EN010092 Thurrock Flexible Energy Centre

Gravesham Borough Council

Written Representation (WR) and responses to ExQ1

Figure: 4.14a

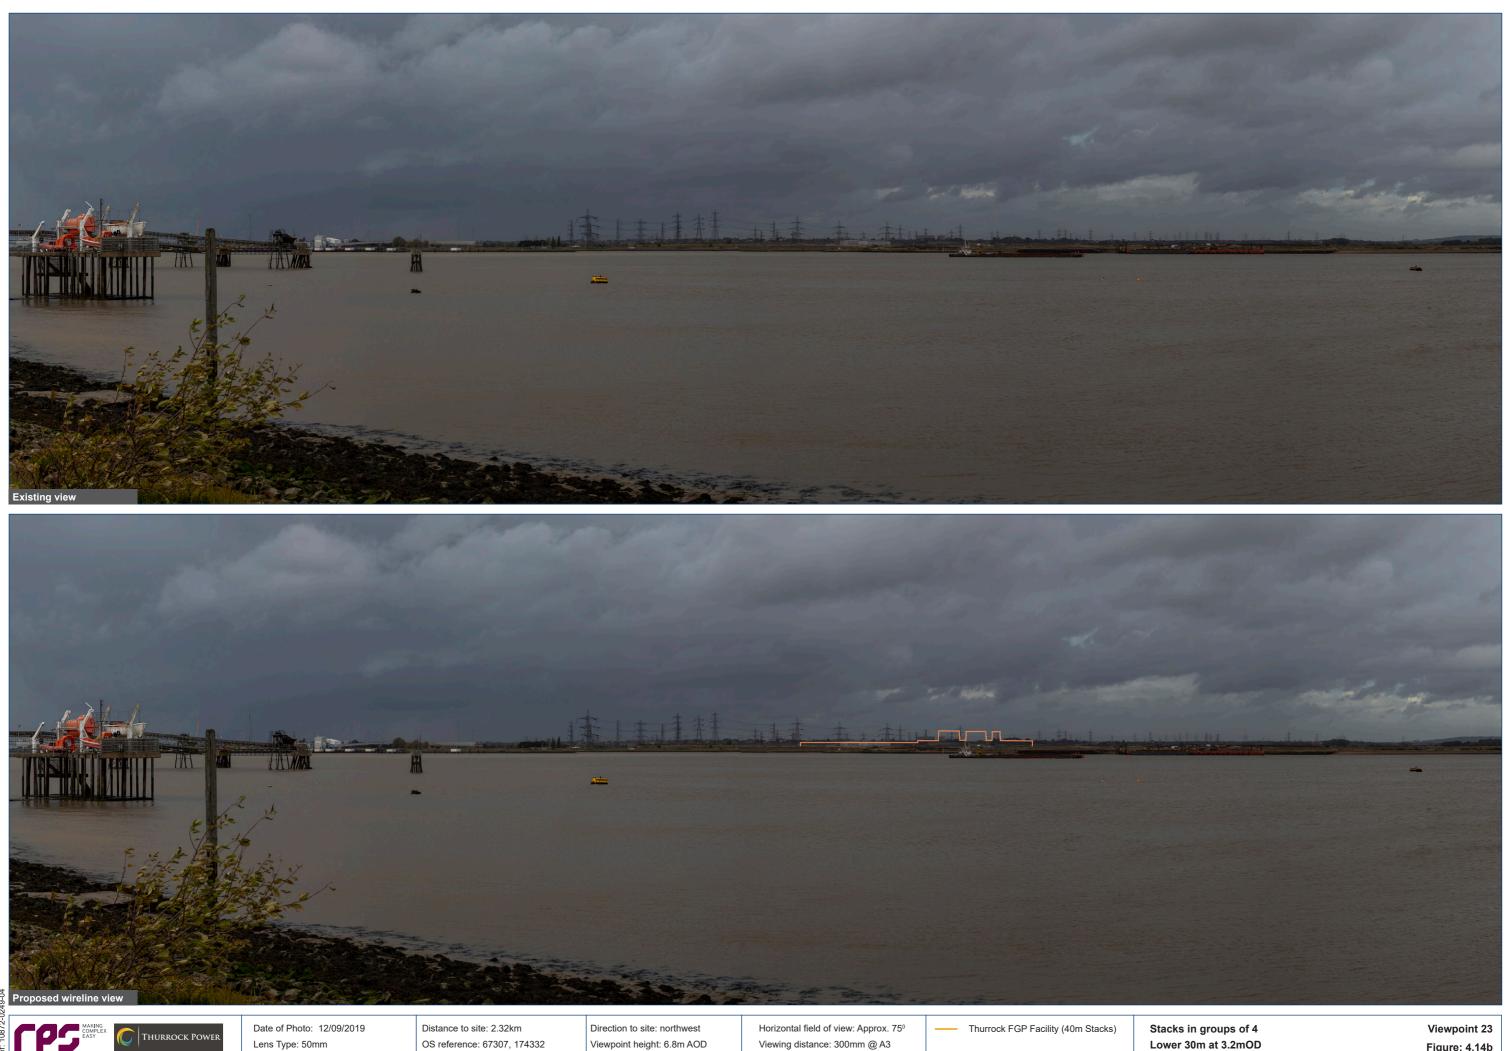
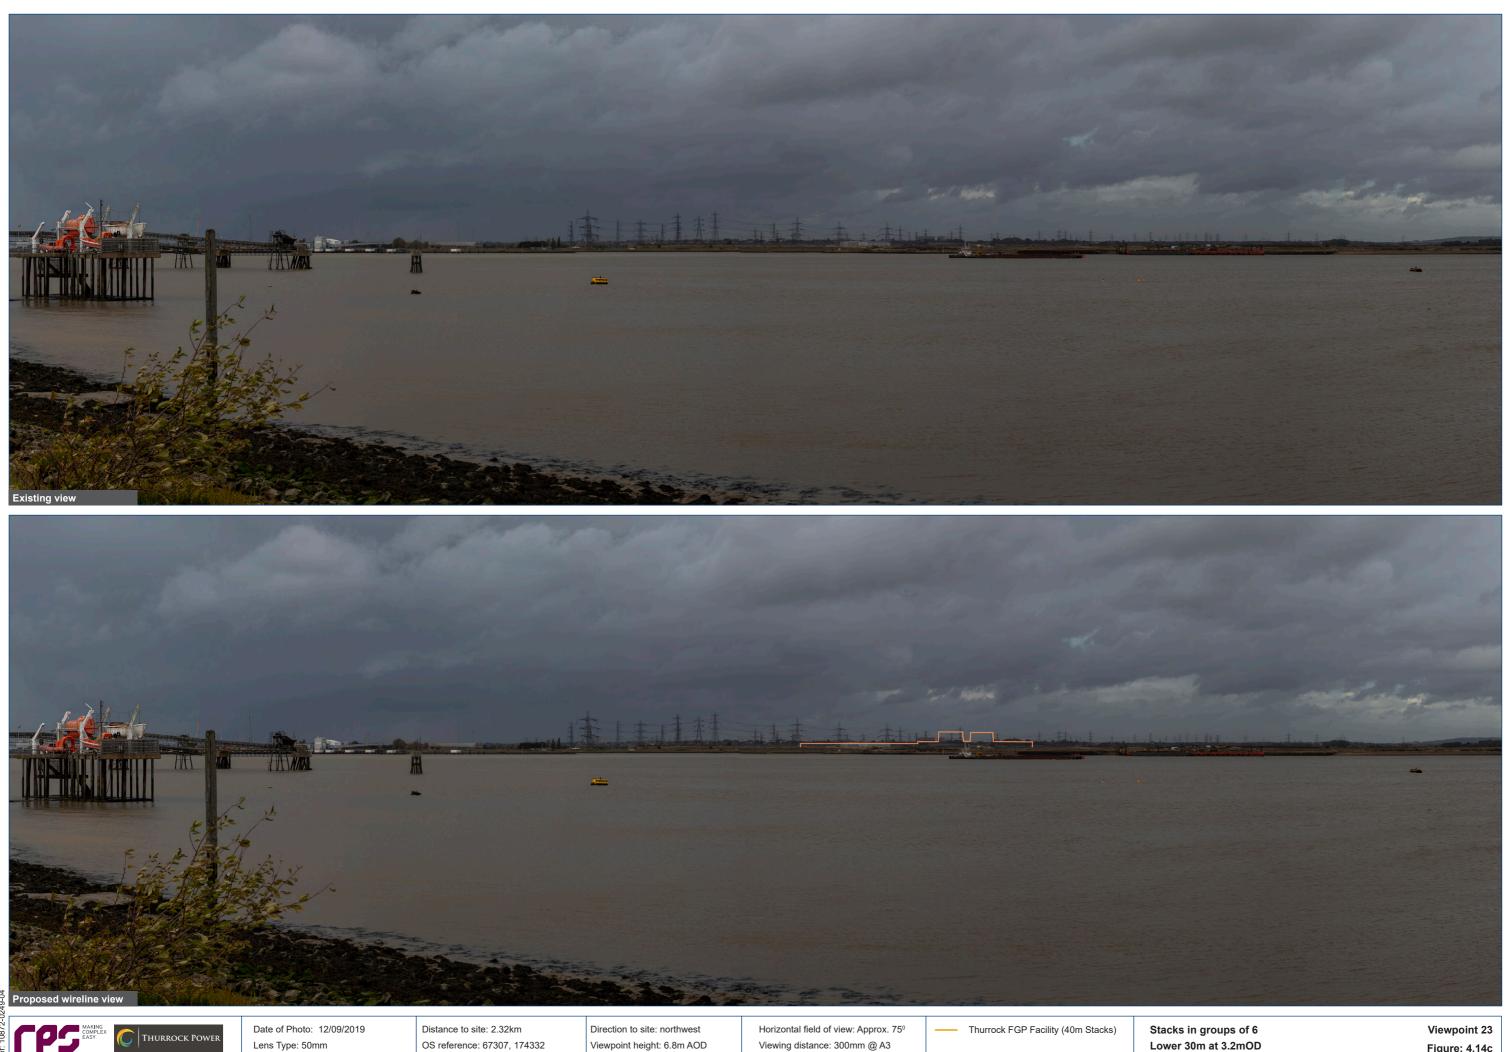
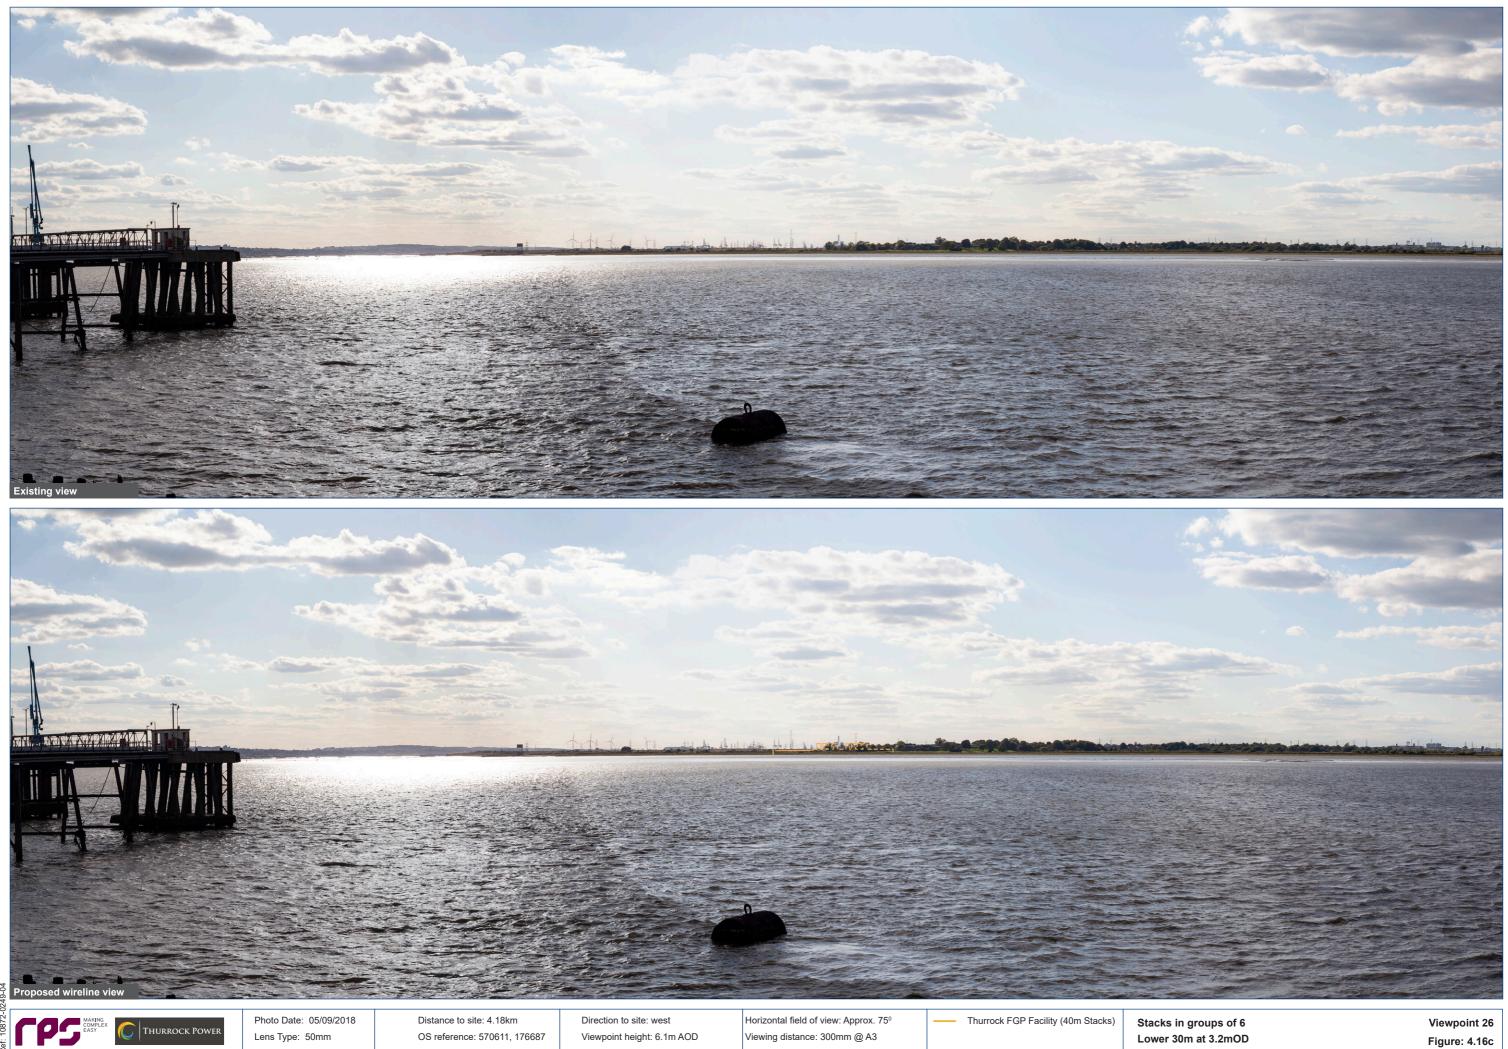
- 5.14 1.12.1 *Have the representative viewpoints been agreed.* The Borough Council has reviewed the landscaped views provided by the applicant in chapter 6 of the ES, the locations of which were previously agreed by the Council. In terms of the operational plant itself the views illustrate that the stacks, as the highest element, are generally not prominent in long distance views or else become lost in the pylons and other structures that exist in any case.
